CITY OF ALBUQUERQUE

**Planning Department
Transportation Development Services Section**

Re: Certification Submittal for Final Building Certificate of Occupancy for
Meridian Business Park (Office bldg, Lot 17-B), [K-10 / D023H]
7550 Meridian Place
Architect's Stamp Dated 08/20/08

DATE: AUGUST 21, 2007
 NORTH: SCALE: 1"=20'-0"
 DRAWING NAME: SITE PLAN FOR BUILDING PERMIT
 SHEET NUMBER: SDP-1

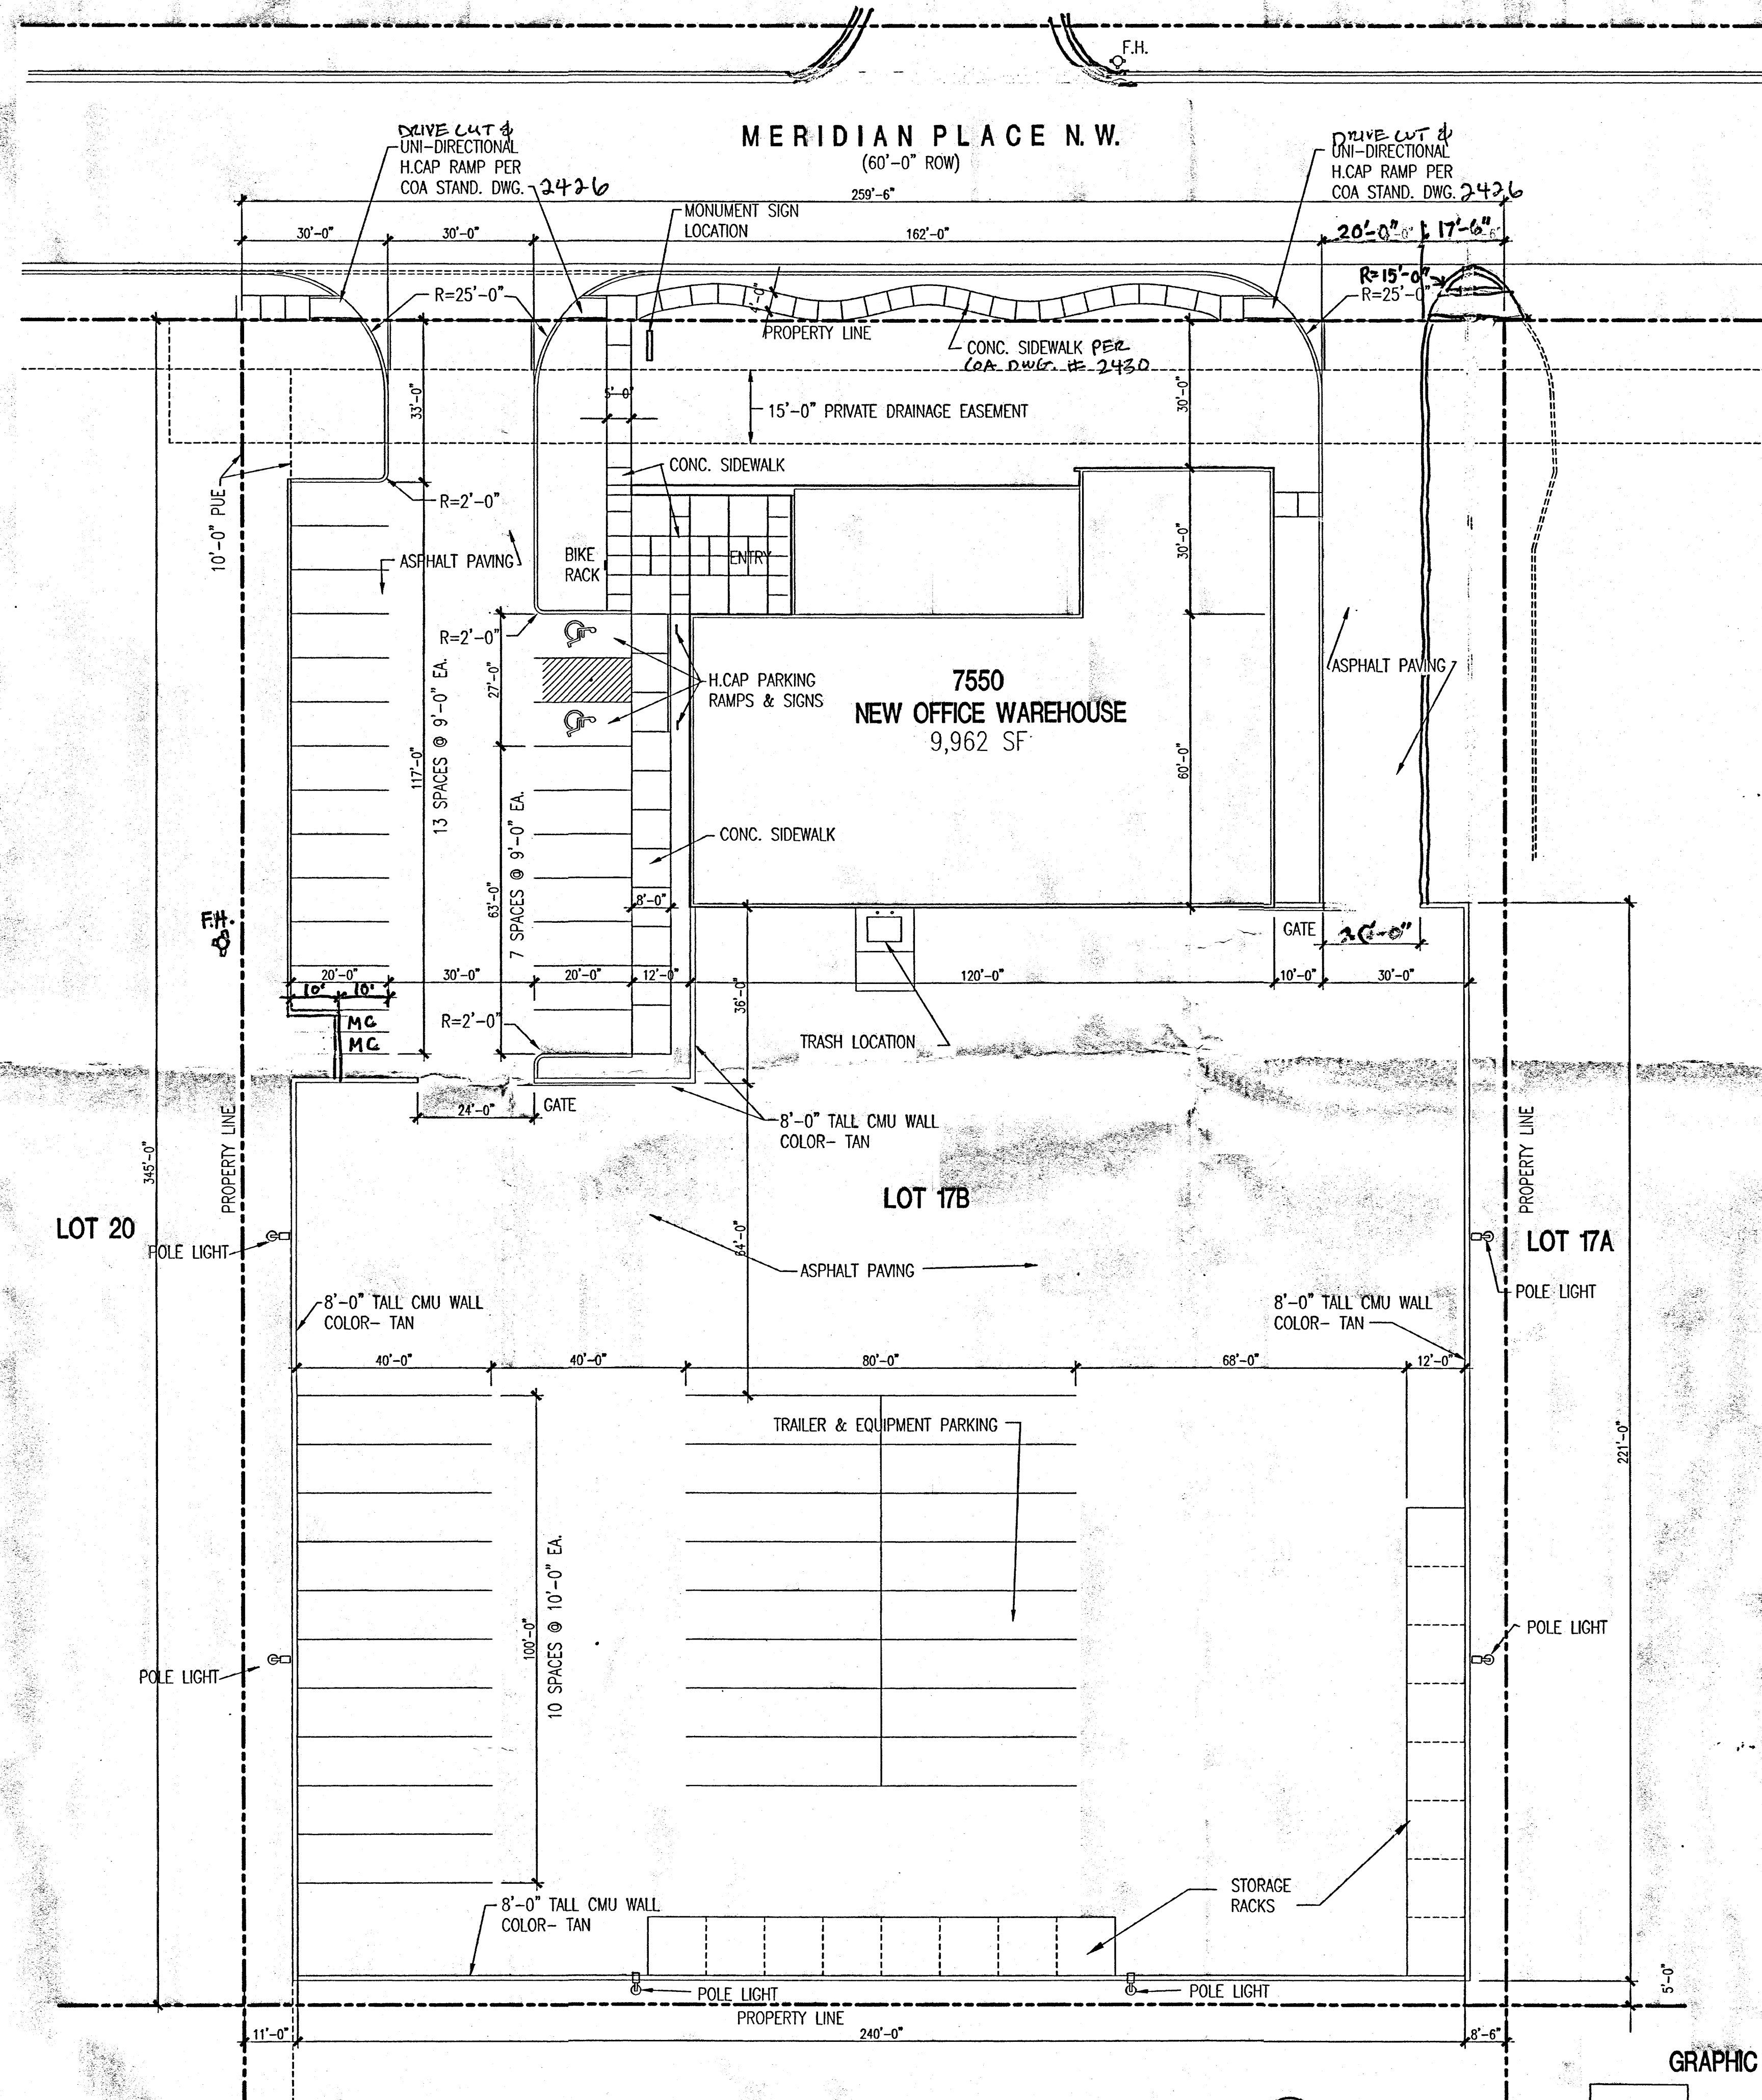
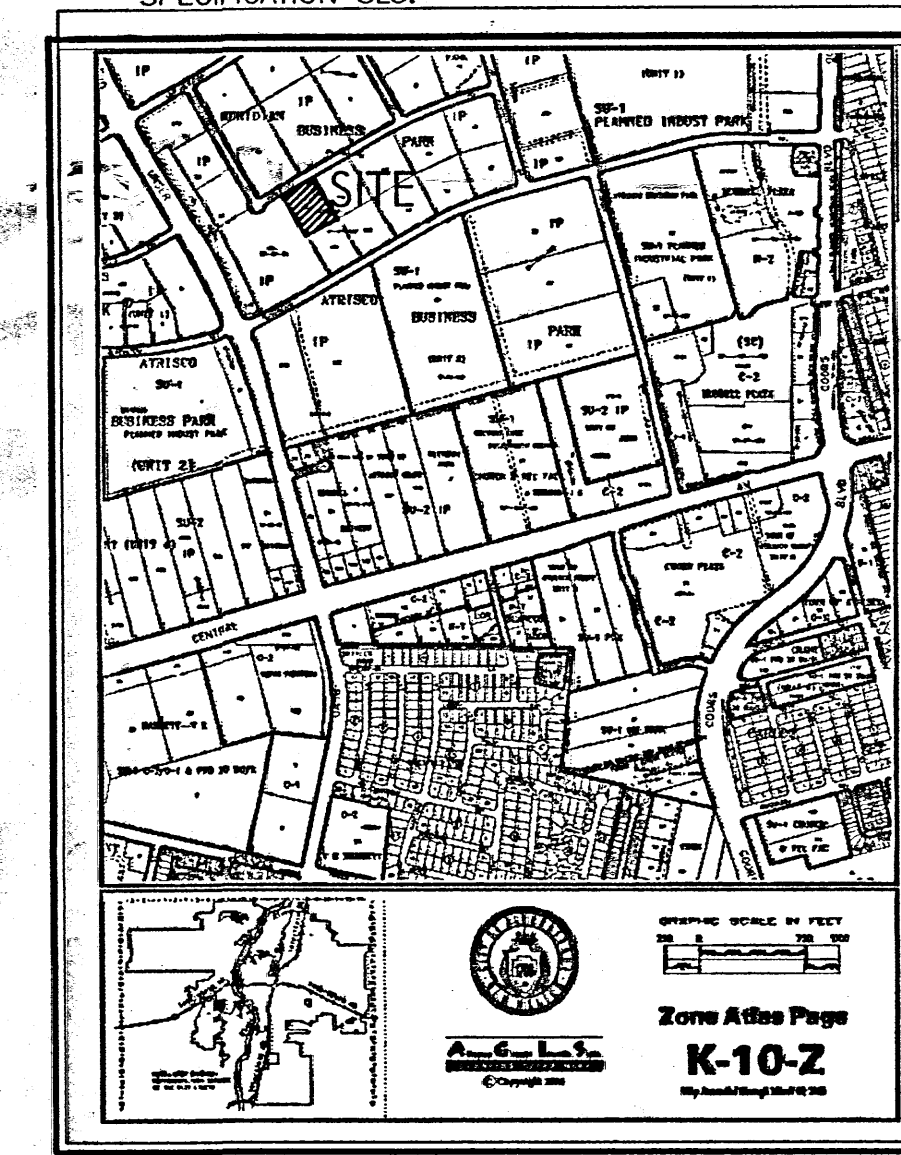
A Temporary C.O. has been issued allowing the outstanding changes on Site Plan (need to initial if not part of original approval) and you need to provide a ramp detail on Northeast entrance (detail to include detectable warning surfaces) issues to be completed within this time period. When these remaining issues have been fully completed, are in substantial compliance, and a final Certification for Transportation has been resubmitted to the City's Hydrology office for approval, a Permanent C.O. will be issued.

We received your letter dated July 11, 2007 concerning the TCL approval for final C.O. on the above referenced project. The detectable warning surfaces have been installed at the site and we have noted the changes on the approved DRB plan which is attached. We have observed that the completed site work is in substantial compliance with the approved drawings. Please contact this office with any questions.

1 GRADING PLAN
1" = 30'

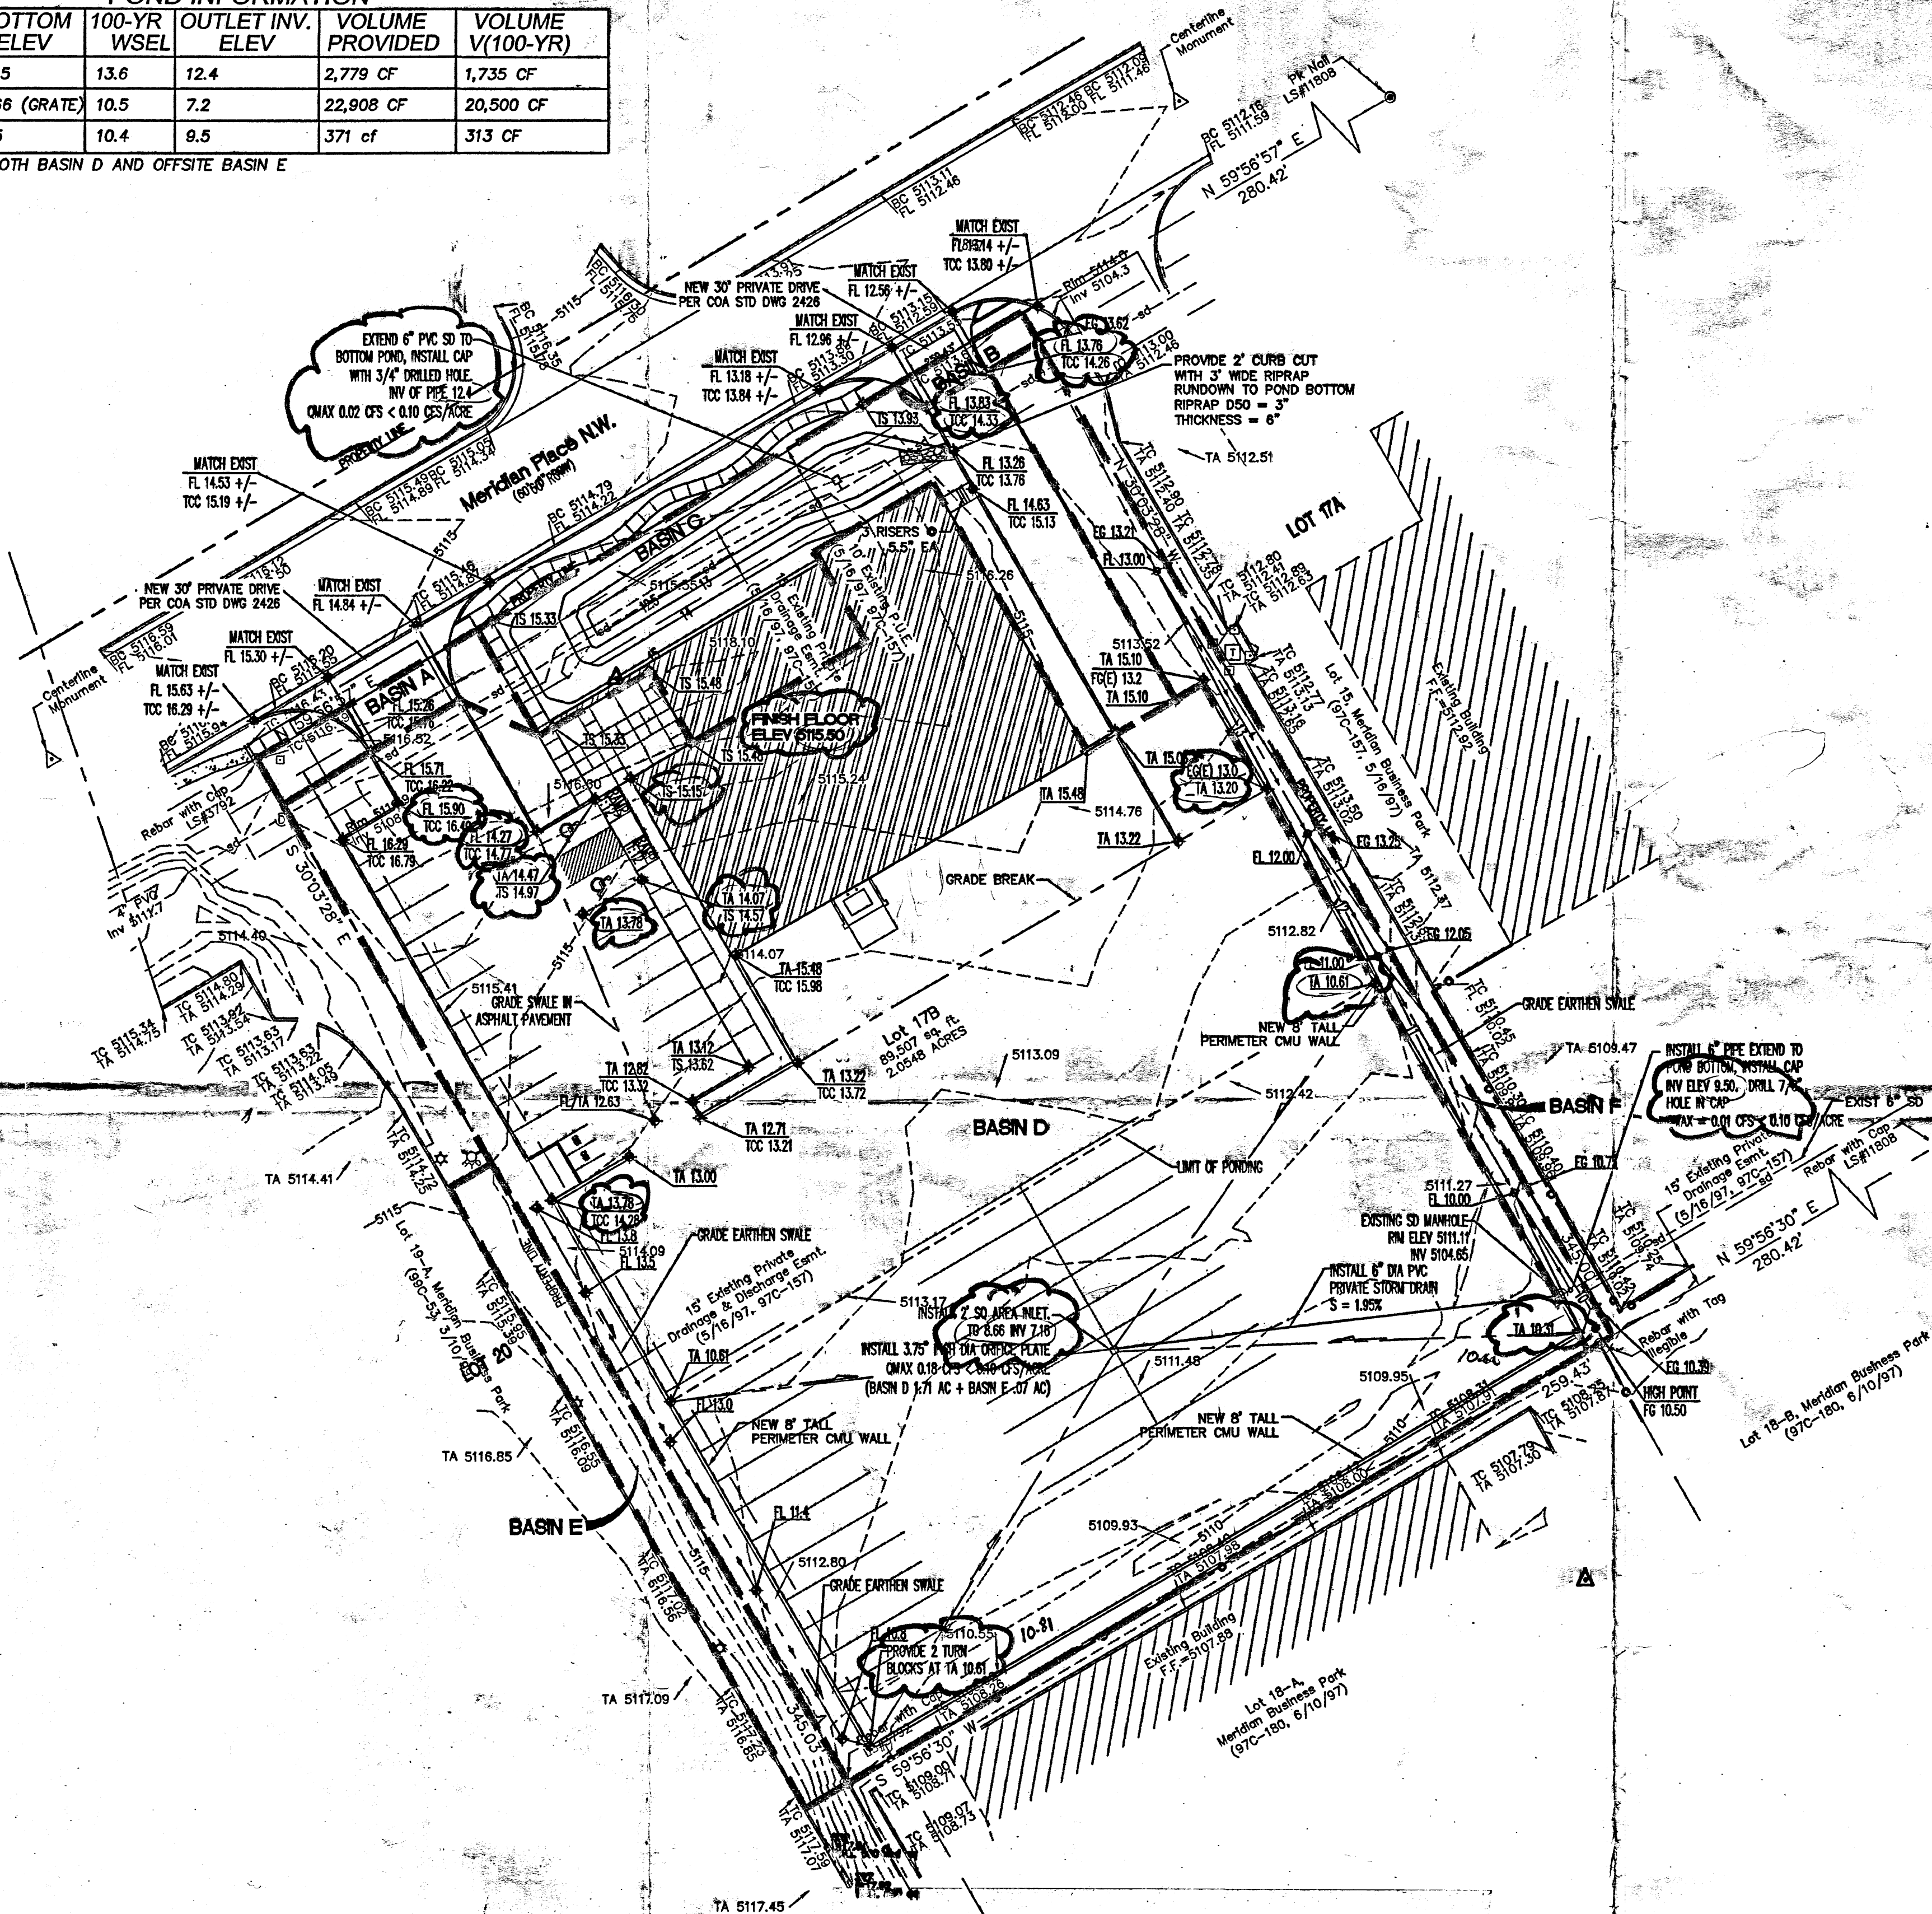
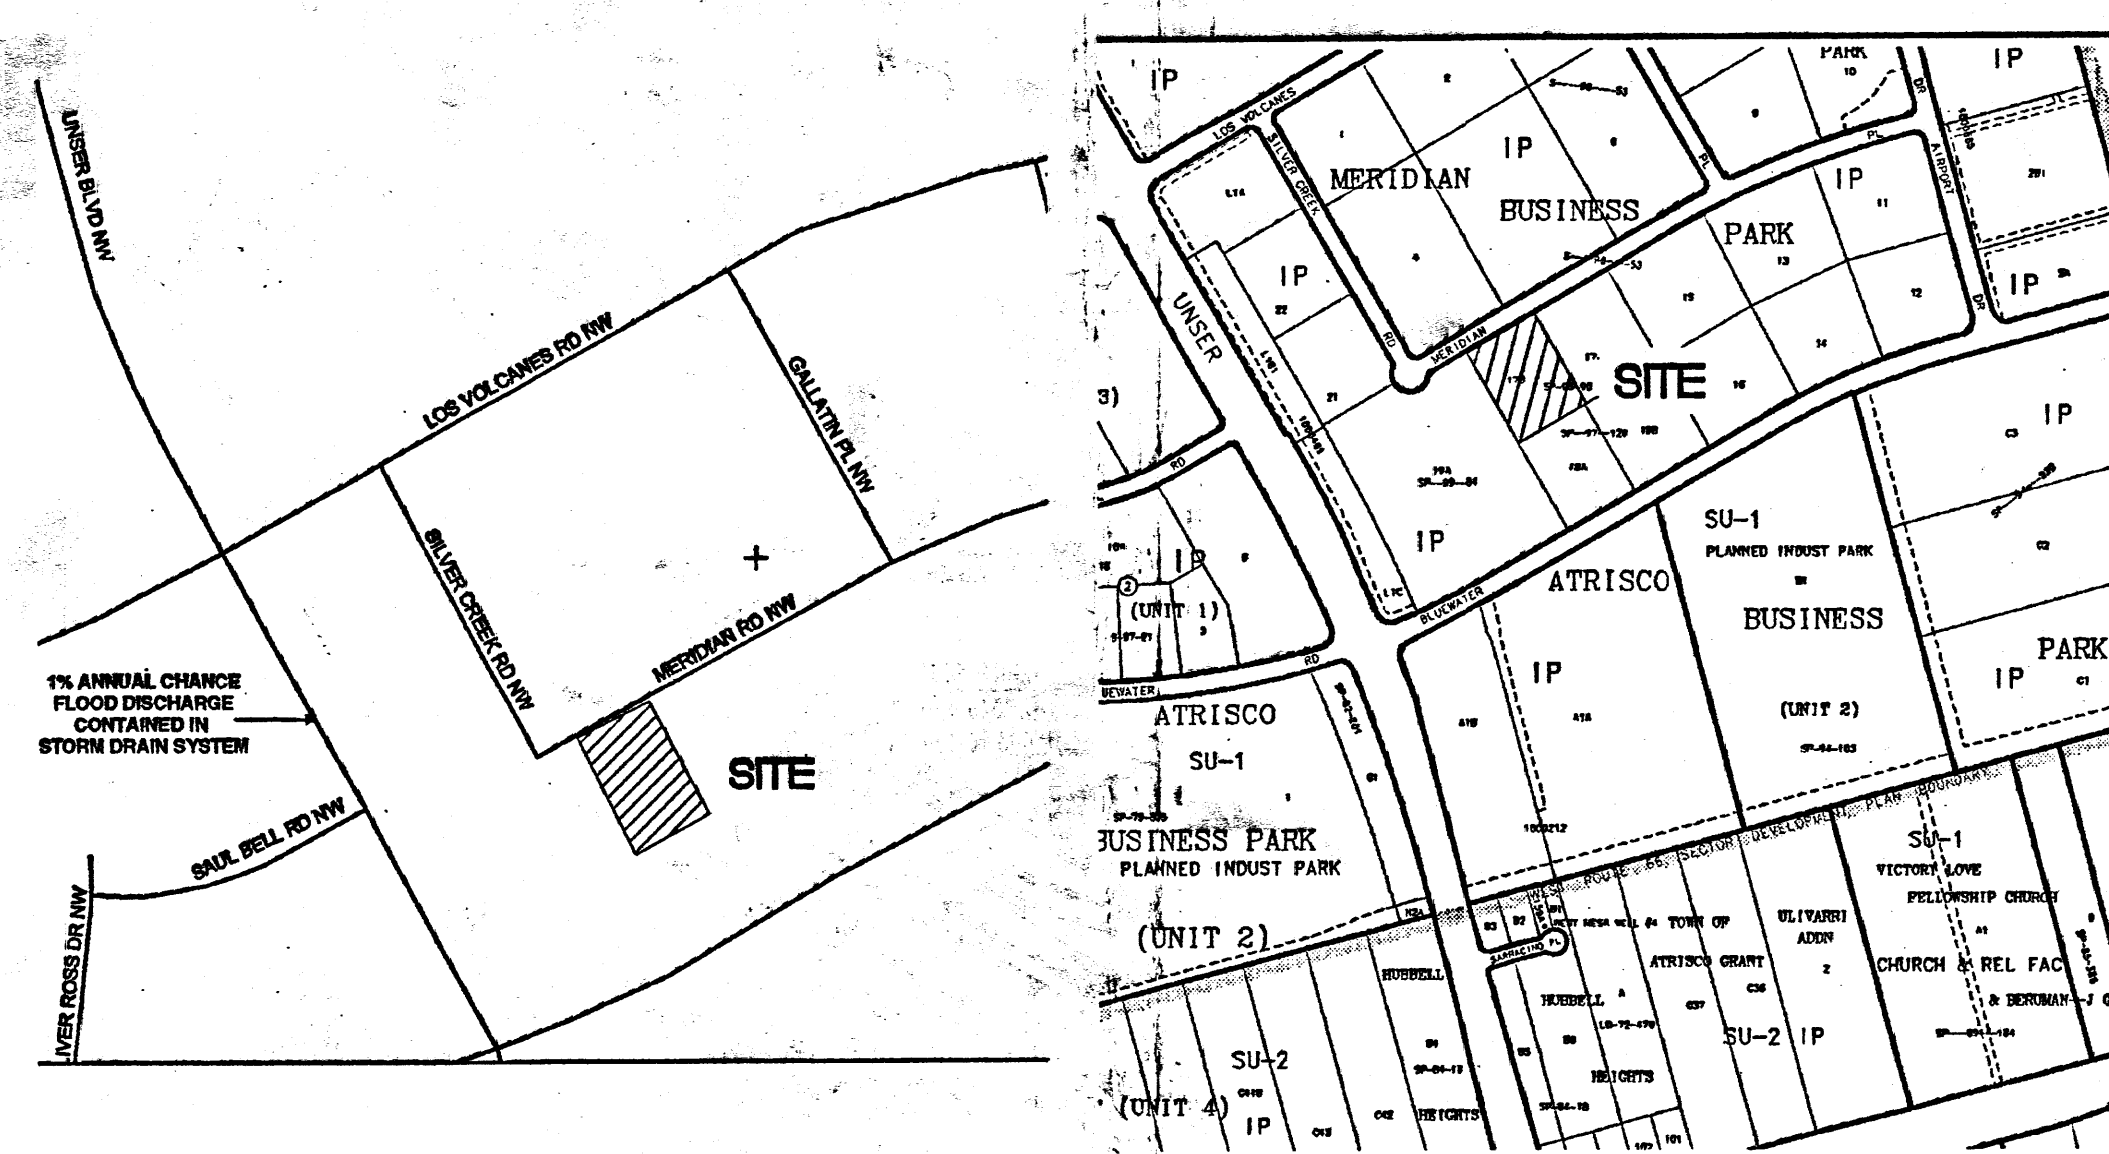
1. There are calculations for Modesto Row, what is this area?
2. Where are the calculations for each of the basins?
3. Where are the pond bottoms located, what are the inverts at these locations and what are the water surface elevations?
4. What are the elevations surrounding this site?
5. There appears to be rip-rap in basin C. What is this for what is it made of and what are the elevations?
